Re: Sather-VanEss Phase 2 Sewer Extension SEPA
PA22048

MEMORANDUM

RE: VanEss Sewer Extension, File# PA22-048
SEPA Application
Parcel #'s 310529-002-014-01, 310529-002-013-00, 310529-002-005-00

SHEET
C1 of C7
24x36
PA22-048

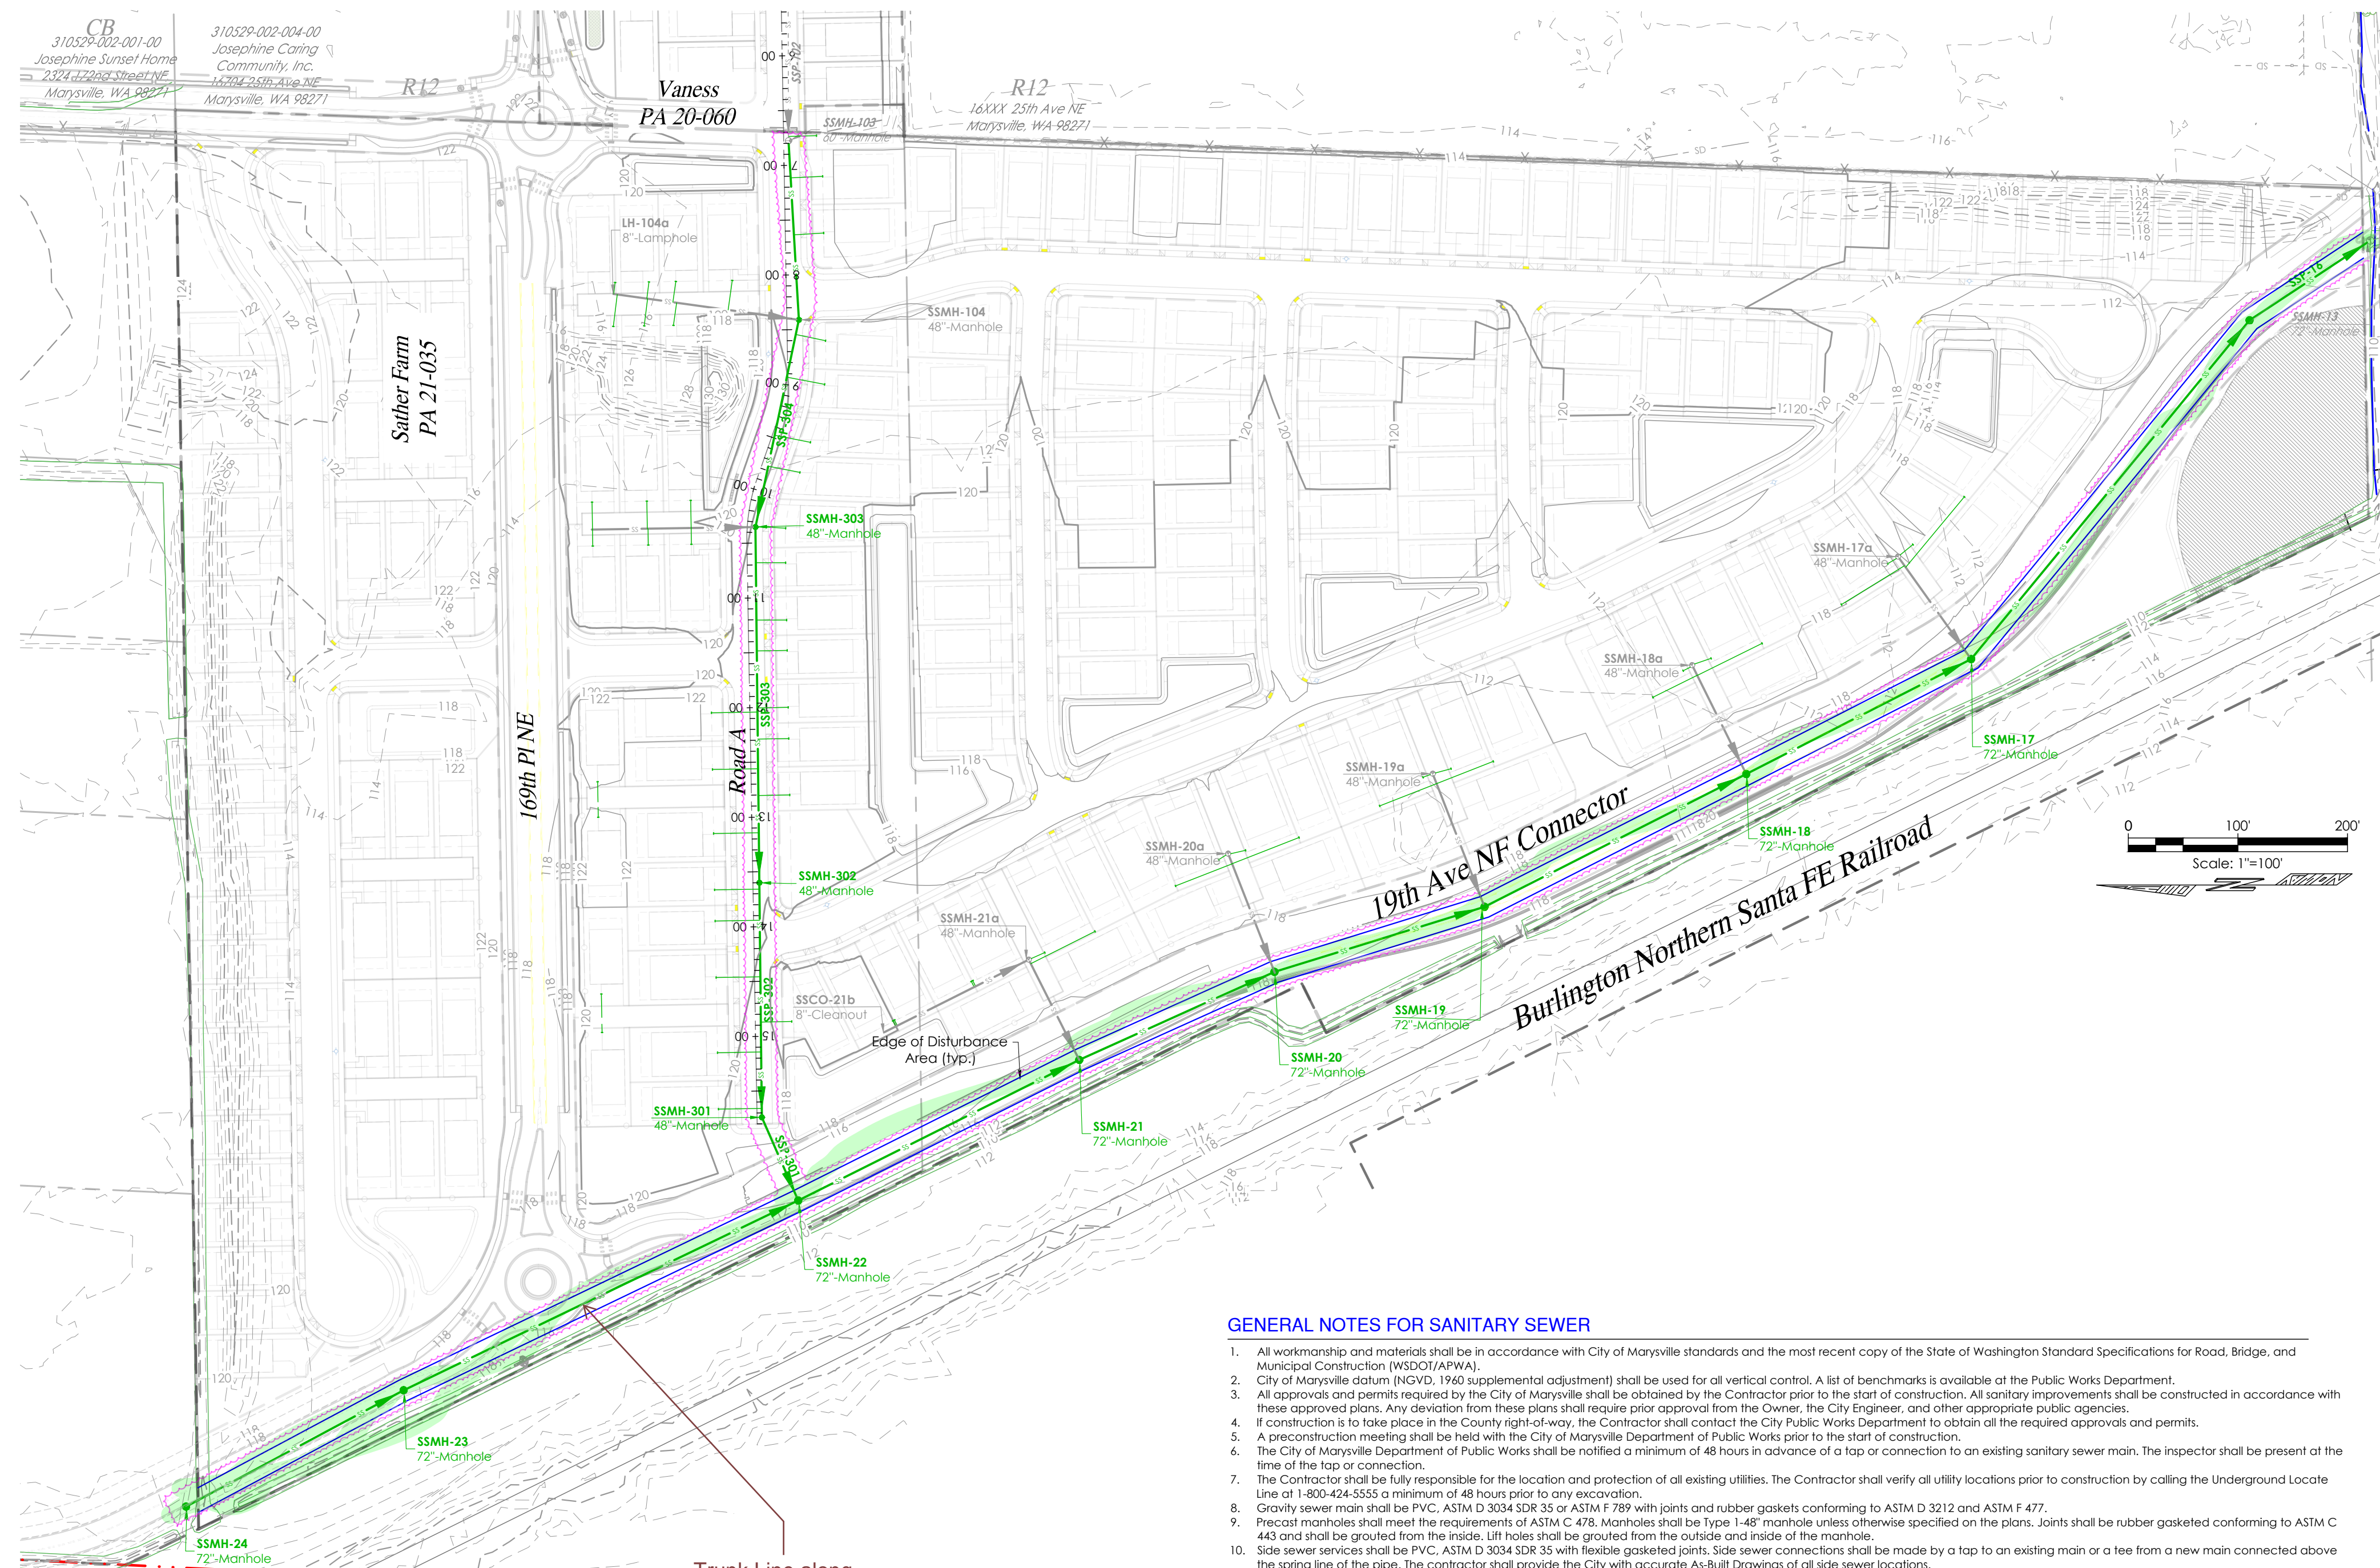
- Is there a wetland delineation report attached to this project? The wetland in the southwest corner of the project site looks smaller in the plan set than on WDFW web maps and on Marysville critical areas map. Additionally, it would be helpful if all wetland buffers were clearly labeled on project drawings. A wetland and WDFW critical area is located directly north of 164th st. above proposed sewer line (not depicted in plan drawings). The location for the dewater discharge is directly between the 164th st. wetland and the Gissberg/Twin Lakes. This does not seem like an appropriate location for dewatering. Labeling these features with buffer distances would be helpful in seeing just how far away the proposed dewater area and sewer line is to these water features/critical areas.
